19 June 2018

Our Reference: SYD10/00613/07 (A21530501)
DP&E Ref: MP09_0180 MOD 7

**BaptistCare Seniors Housing Development,
Clusters 2-4 (Modification 7) at 34-36 Memorial Avenue, Kellyville**

Drawing Number **DA221**
Revision **A**

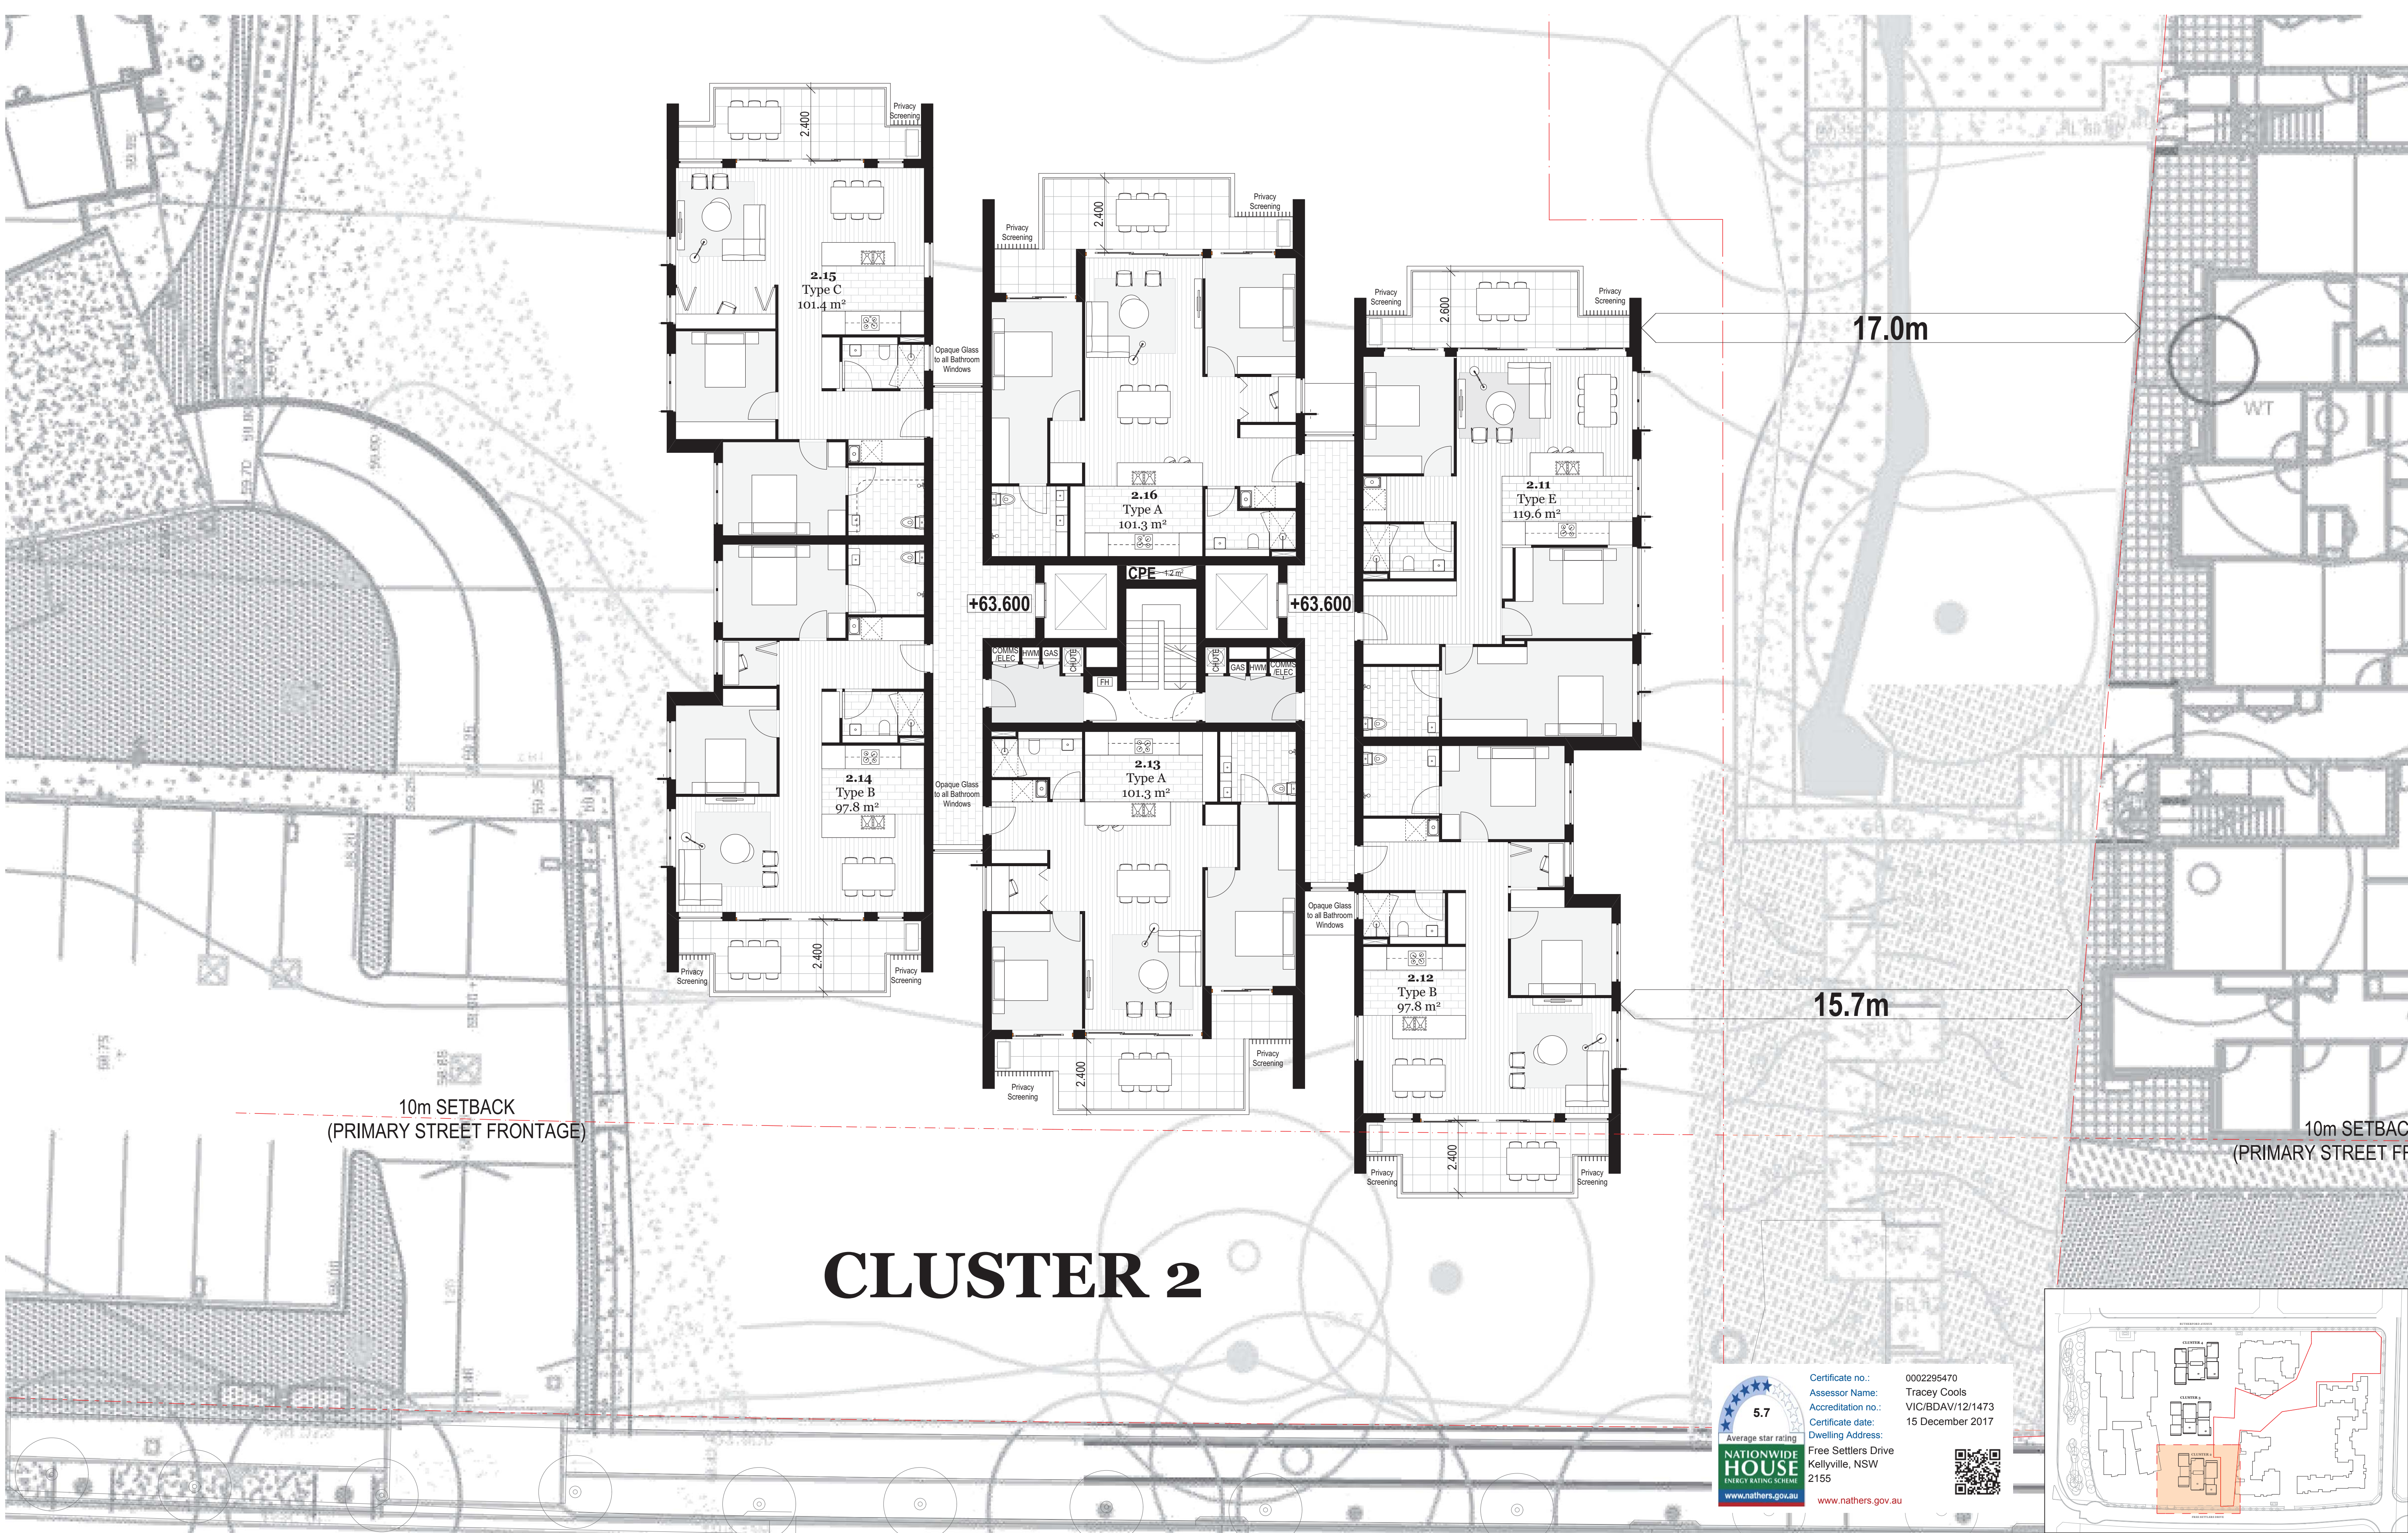
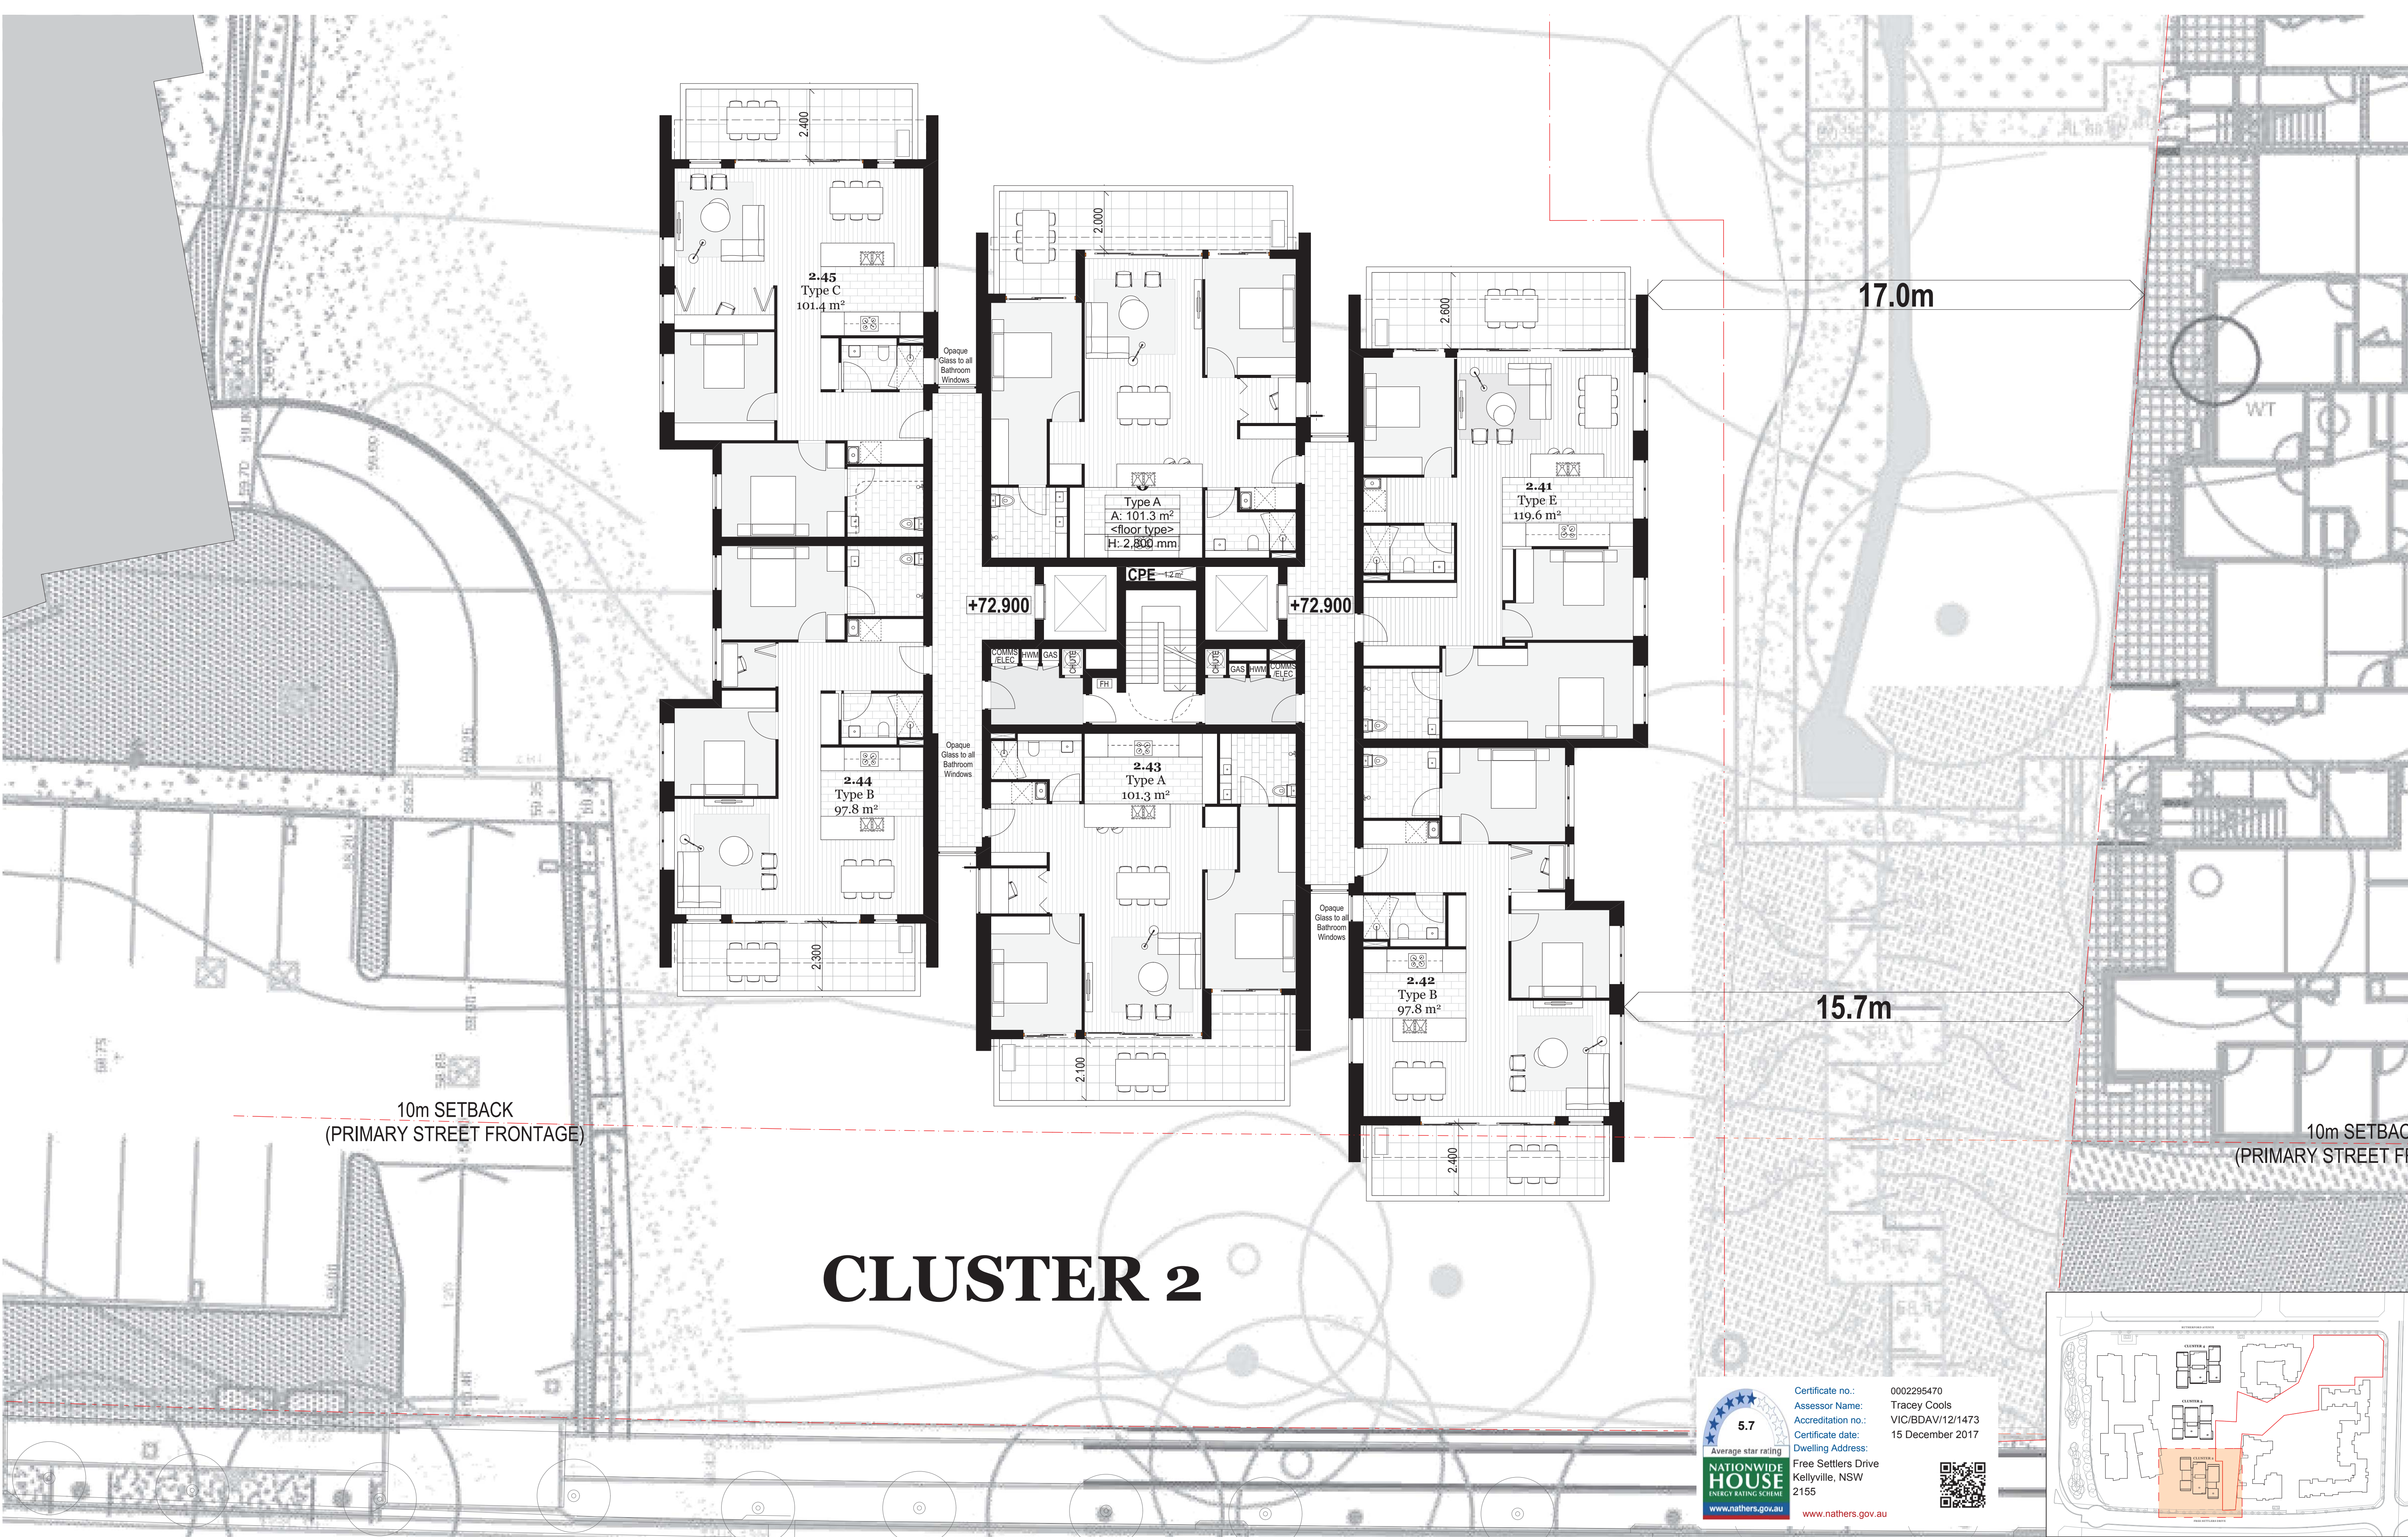
An assessment of the proposed basement garbage/service ramp has identified that the proposed design has potential for an on-going internal conflict point where the ramp connects with the carpark driveway for the adjoining development and the positioning for the proposed Van parking space (refer Drawing DA 221 Revision A and Plan "X" attached to this correspondence). Roads and Maritime has no further comments for the determination of the application.
